Our reference: ECM Ref: 9886173
Contact: Gavin Cherry
Telephone: (02) 4732 8125

Department of Planning, Industry and Environment
Attn: Isaac Clayton
Email: Isaac.Clayton@dpie.nsw.gov.au

Request for Advice - EIS - Nepean Hospital Redevelopment Stage 2 SSD-16928008 at No. 35 Derby Street, Kingswood

Figure 4.2-G: Proposed 600mm stormwater pipe replacing existing 375mm pipe from the East end of Barber Avenue

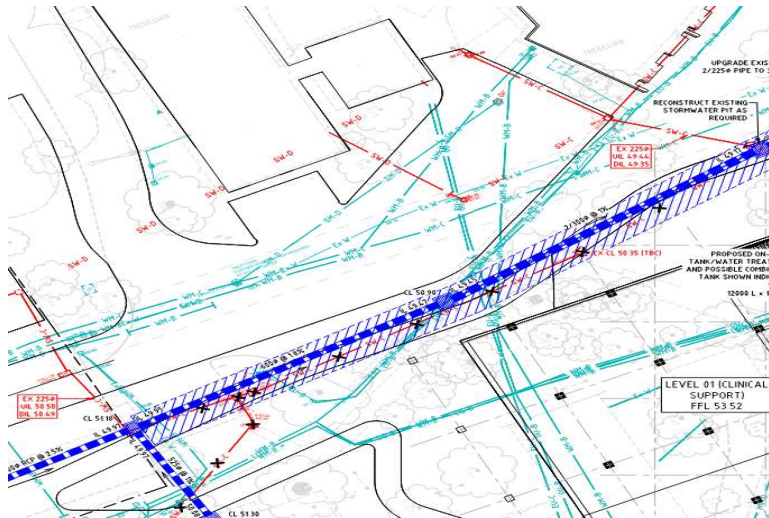
- i) It is acknowledged an upgrade and relocation of the stormwater drainage system is proposed from the eastern end of Barber Avenue through to the existing drainage system in Stage 1, ultimately discharging into the stormwater system in Somerset Street. No objections / concerns are raised by Council if ownership of the downstream drainage system from Barber Avenue remains with Nepean Hospital, however as the drainage system drains a public road, a drainage easement will be required to be created / dedicated over the pipeline in favour of Council (as per the Stage 1 development). If the pipeline is proposed to be owned and maintained by Council, then a Section 68 Local Government Act approval will also be required to be issued by Council for construction approval of the pipeline. The Department is requested to ensure that conditions of consent are imposed to this effect if the application is favourably determined.

Attachment 1 – Western Loading Dock Swept Paths

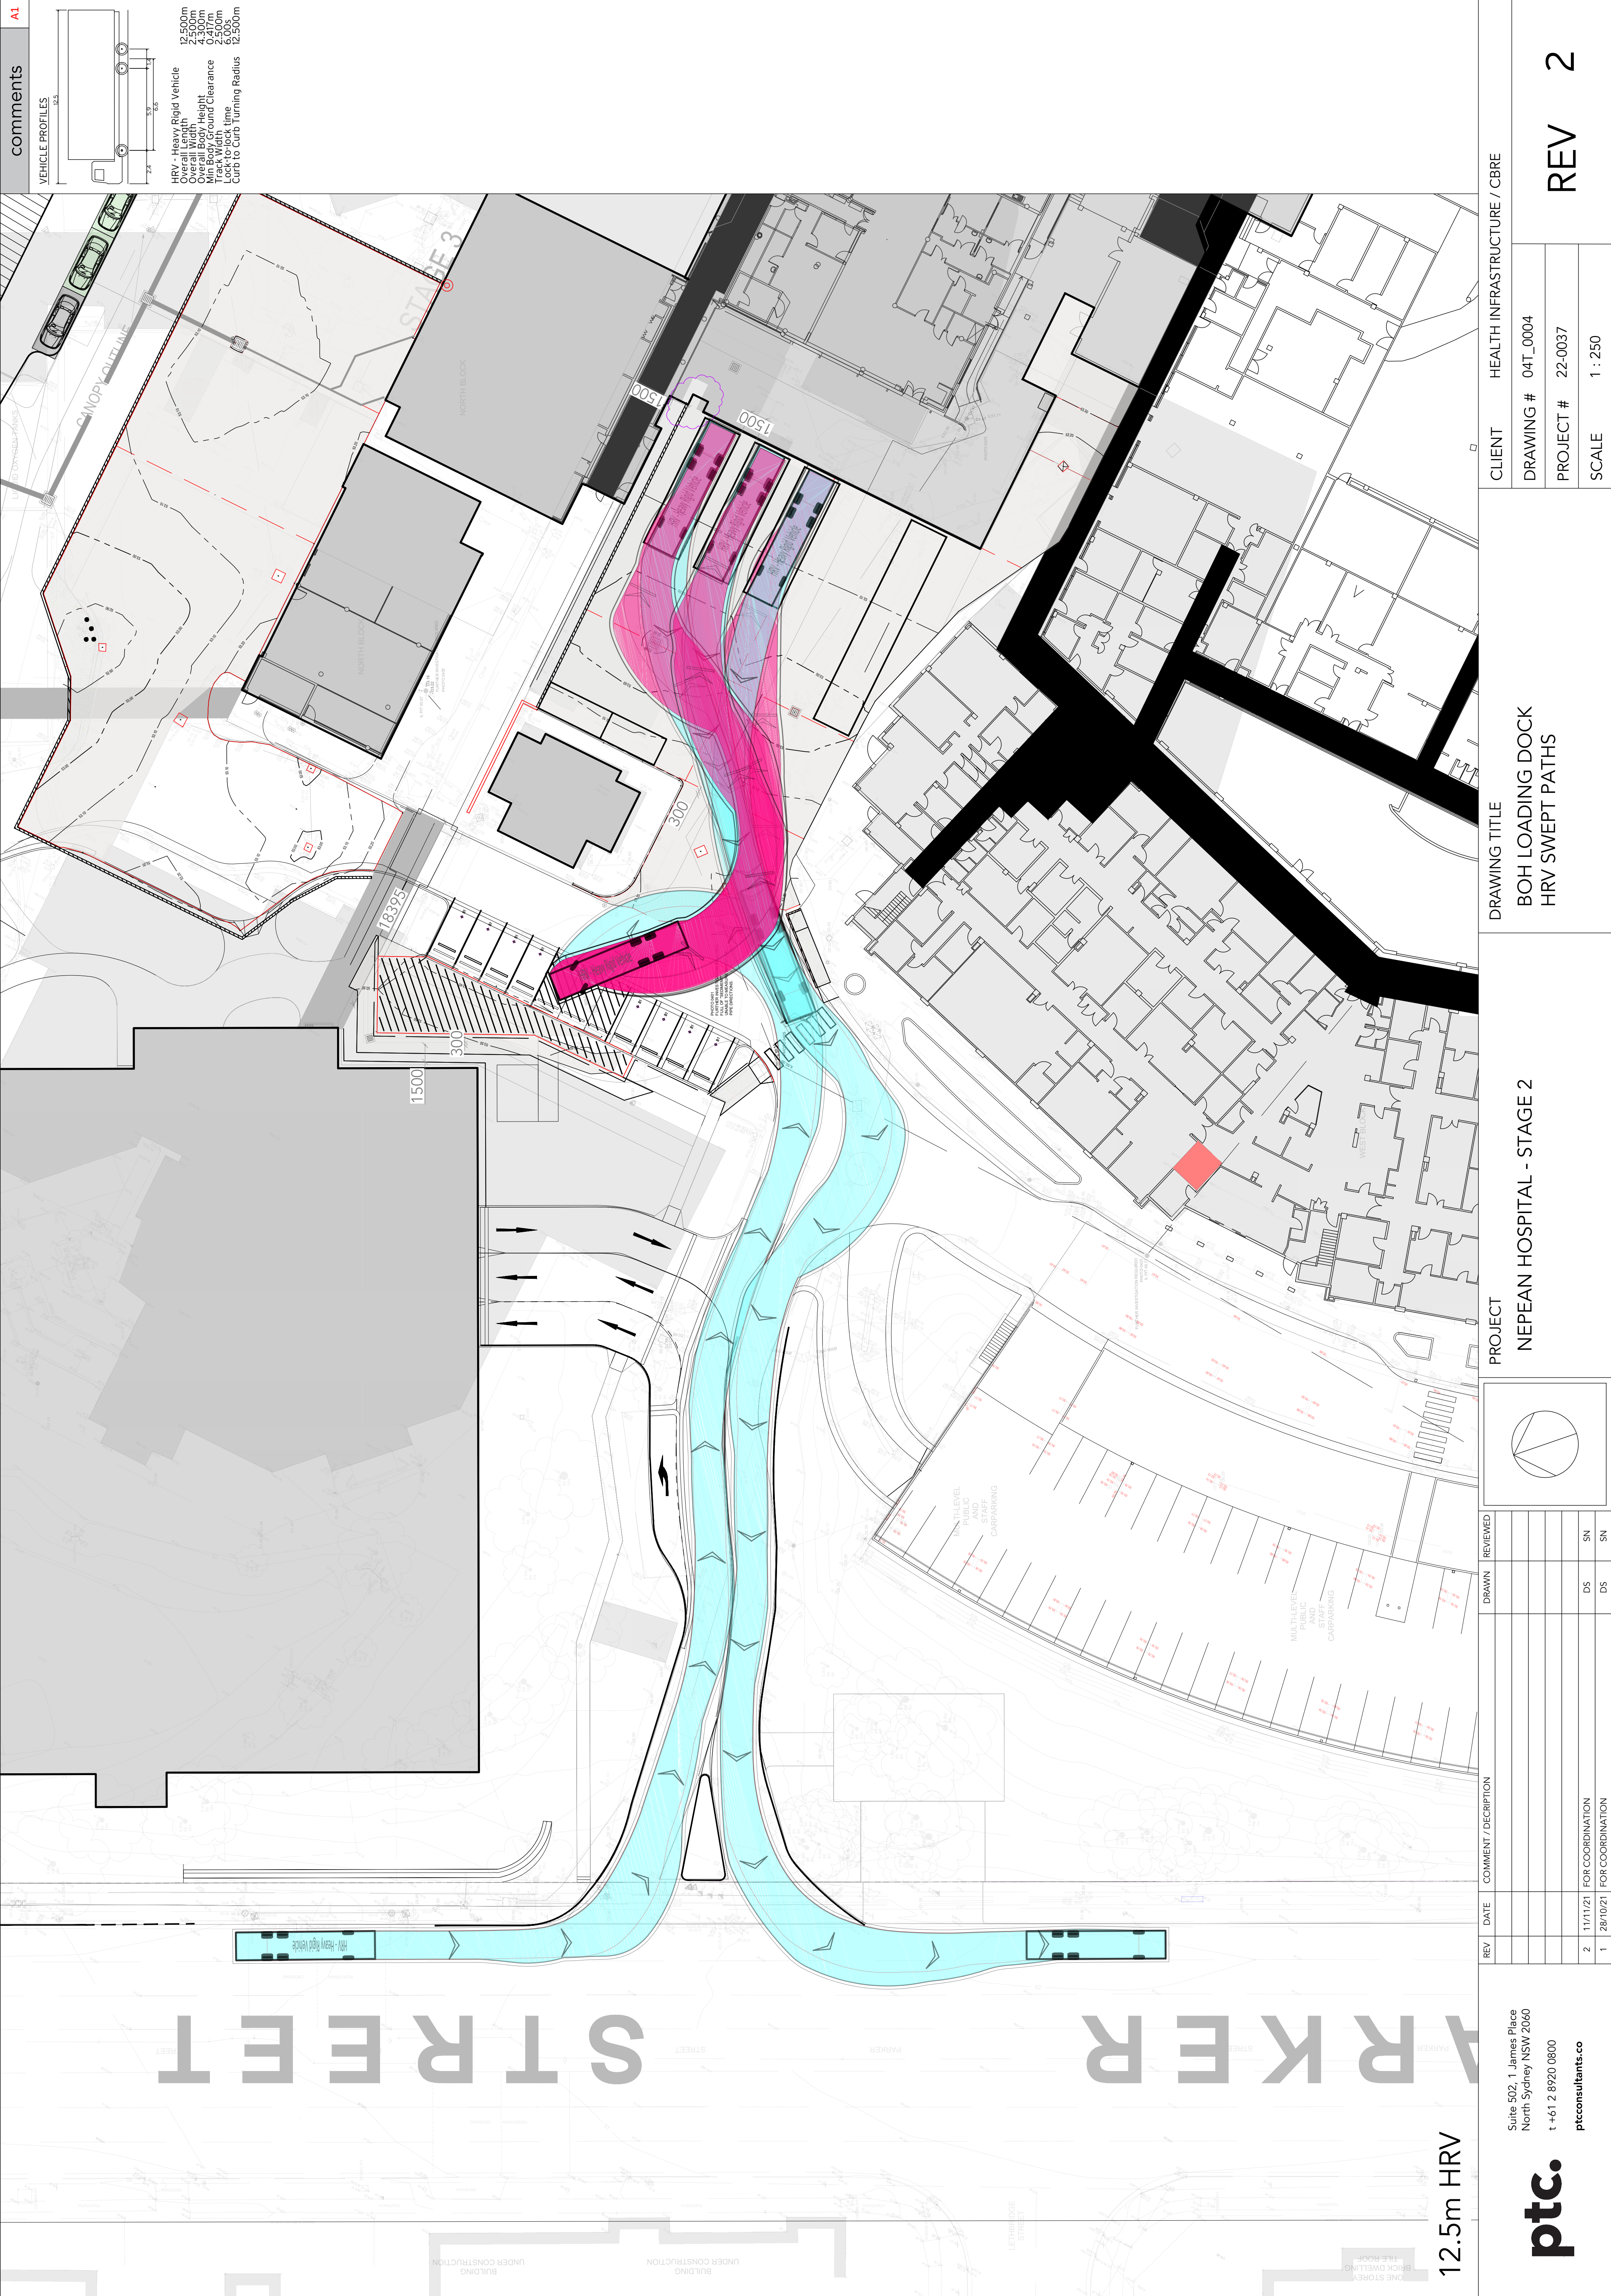
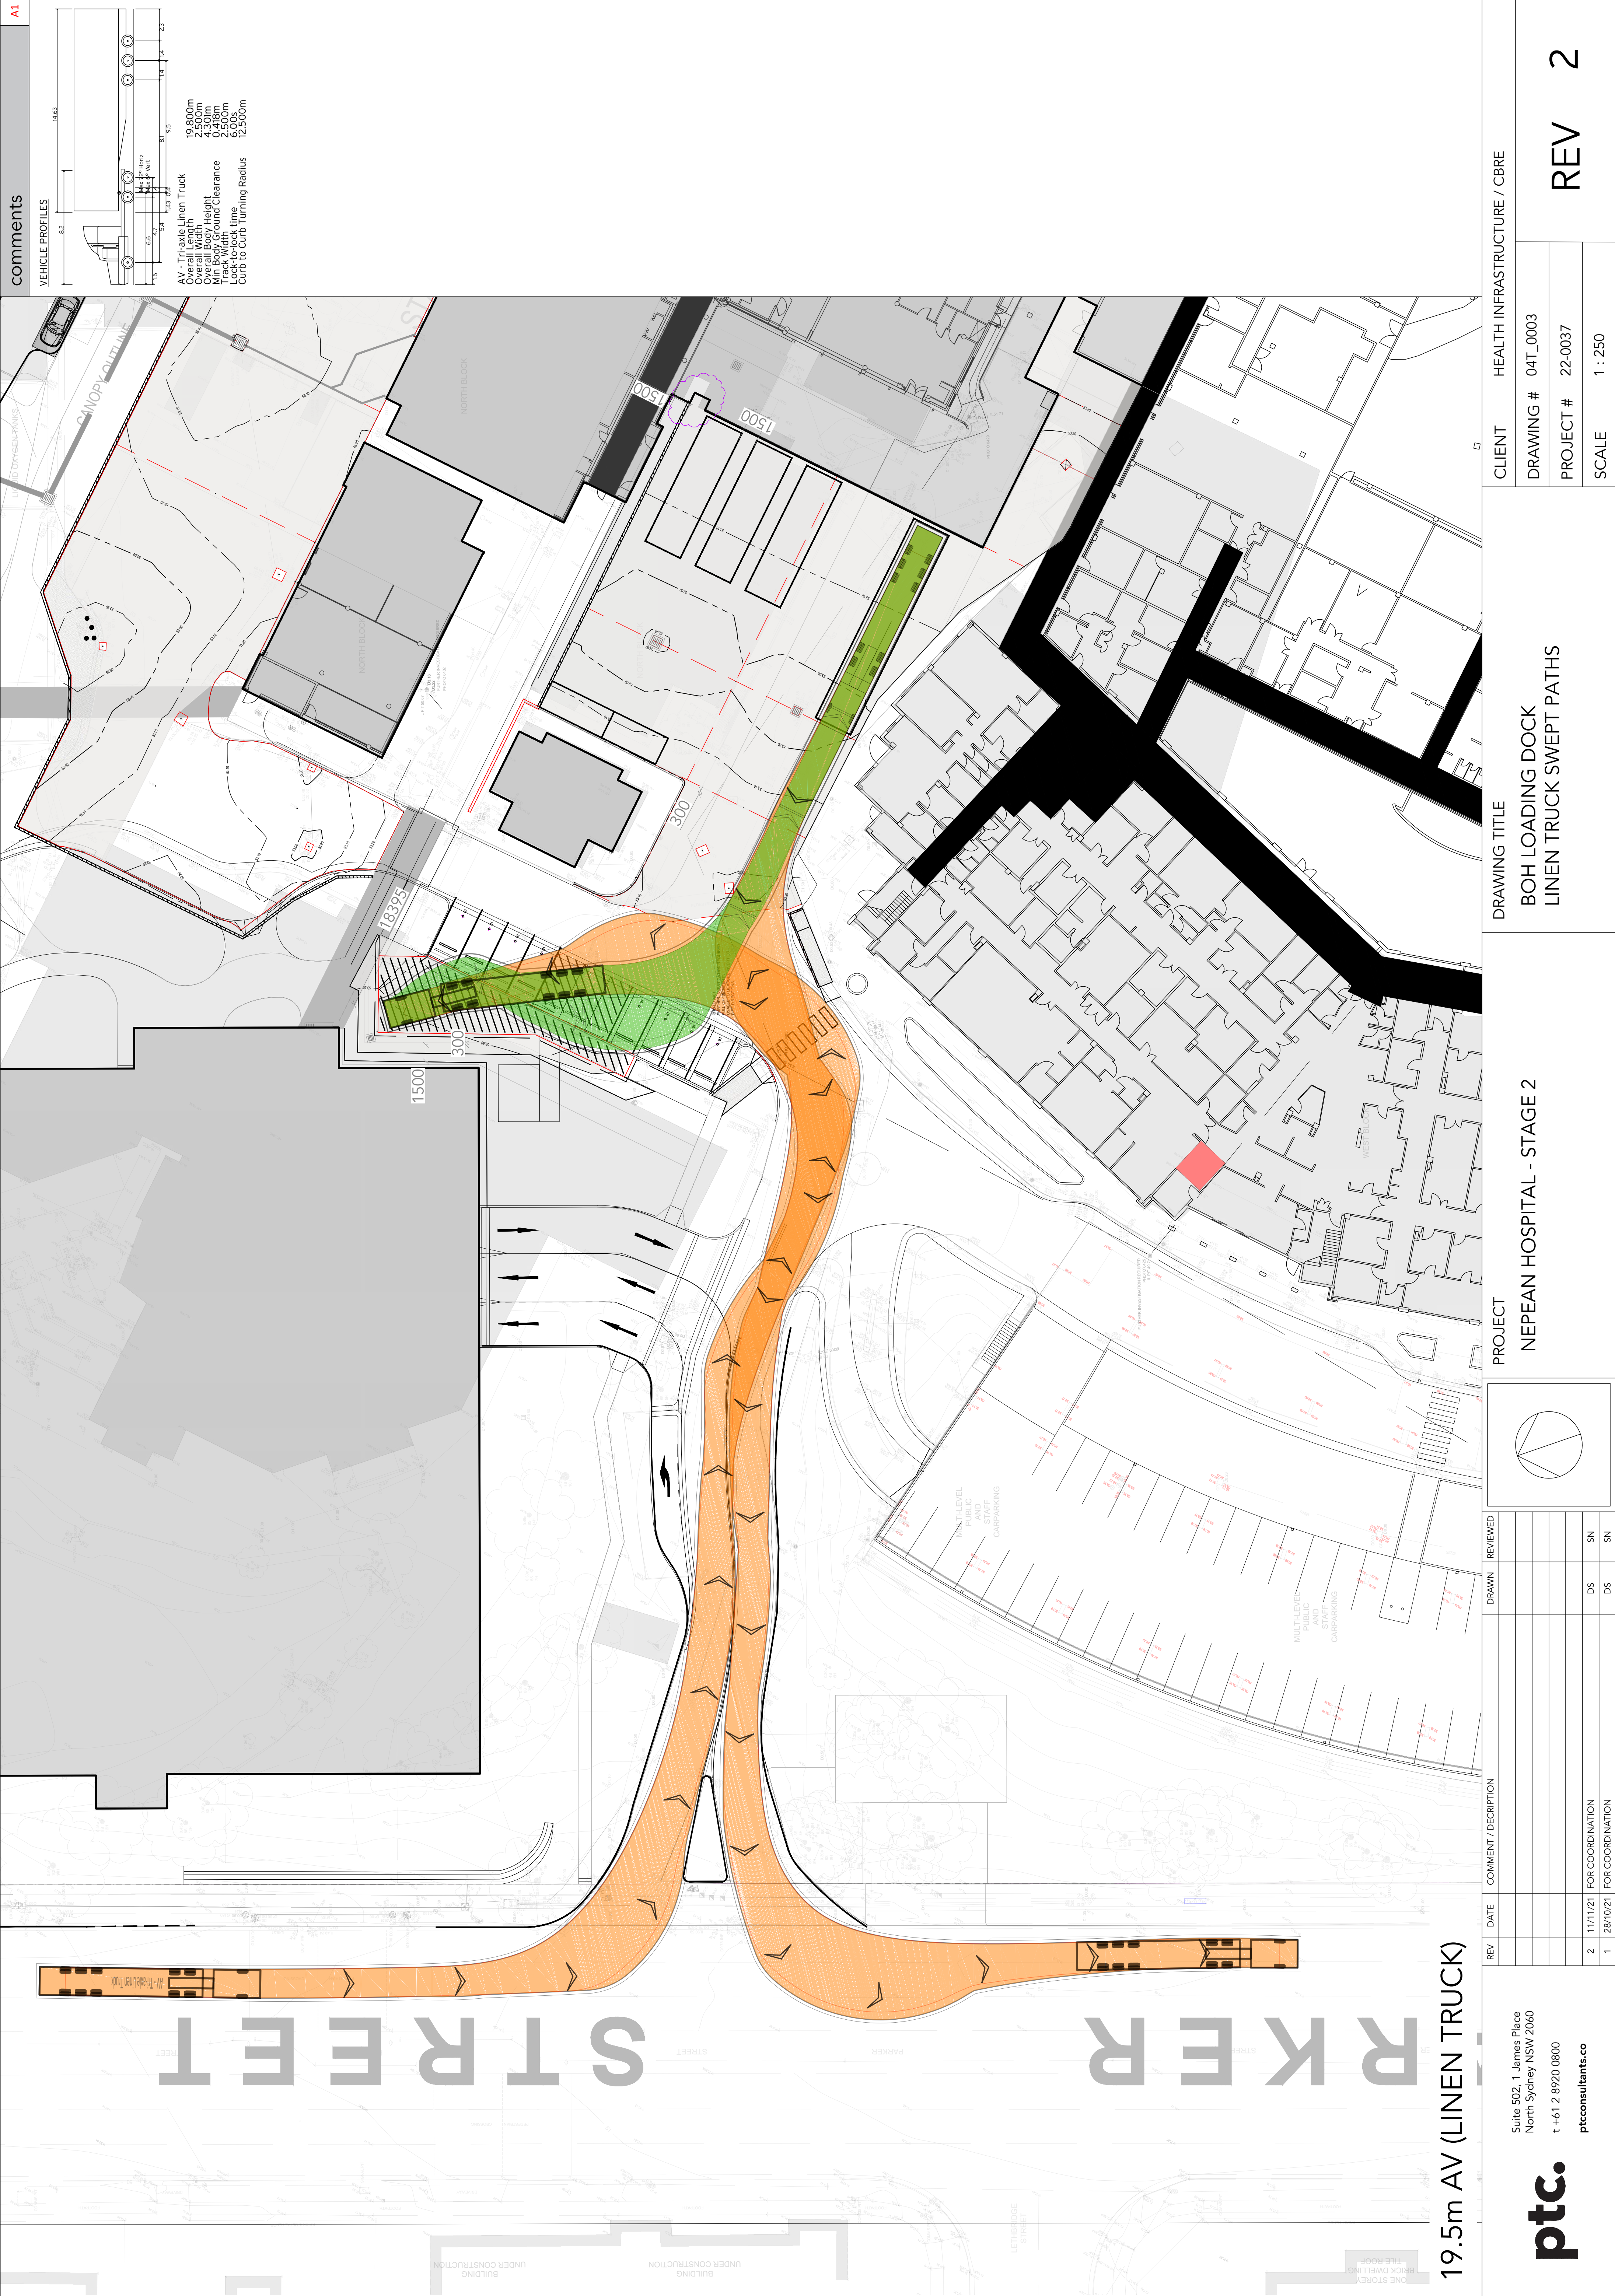
- x) The swept paths for the proposed loading dock servicing arrangements show heavy vehicles reversing over car spaces and crossing into oncoming lanes which is not supported. This requires revision and address.

Figure 4.2-C: Barber Avenue Adjustments

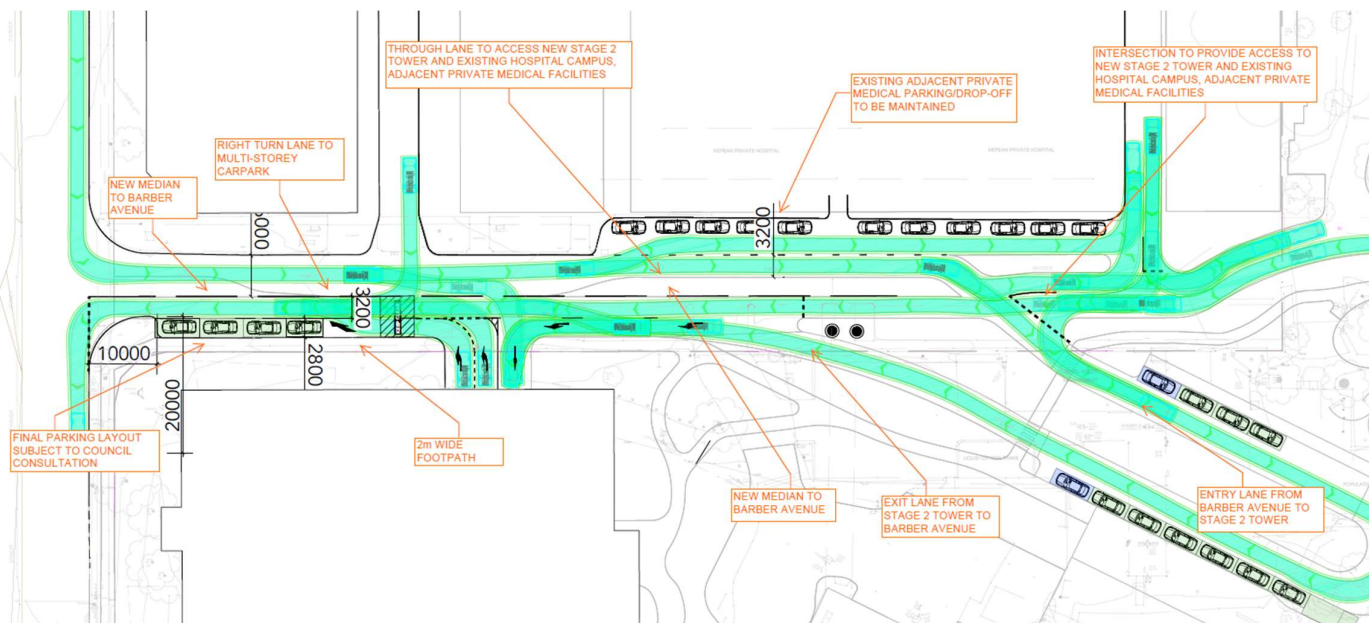
- i) The civil design report and concept design plans indicates that engagement is yet to occur with Council however no engagement appears to have undertaken to inform the current proposal. The suggested works to Barber Avenue are to a public road where Council is the responsible road authority and only Council can approve such works. It is imperative that any works to Barber Avenue and the surrounding local road network are informed by agreements with Council and detailed civil design drawings are provided for assessment. As a result of this, the proposal cannot be supported until such time as this is addressed.

- ii) The following matters are also identified as warranting further consideration and address:-
 - The proposed layout results in a large number of on-street public parking spaces being removed without being replaced which is not a suitable outcome without supplement.

- The proposed layout geometry involves Y shaped intersections however intersections should be perpendicular for increased safety
 - Insufficient detail is provided on how the proposed on street parking will be managed.

- It is yet to be demonstrated that the resulting carriageway width and design complies with Councils road design requirements.
- iii) Section 8.3 of the TIA report indicates an annual background growth of 1.5% is assumed which is not supported. The growth rate of 2% has been applied to all developments within the Penrith City Centre. This growth assessment is based on Council's Penrith Core Centre Transport Management Study and Plan (PCCTMSP) for Future traffic growth of 2% is required by Council (attached an extract the section 5.2). This requires remodelling.

- viii) The removal of 43 on-street parking spaces along Barber Avenue is not supported and the proposal should not reduce existing parking provision noting comments raised within the planning details within this correspondence.
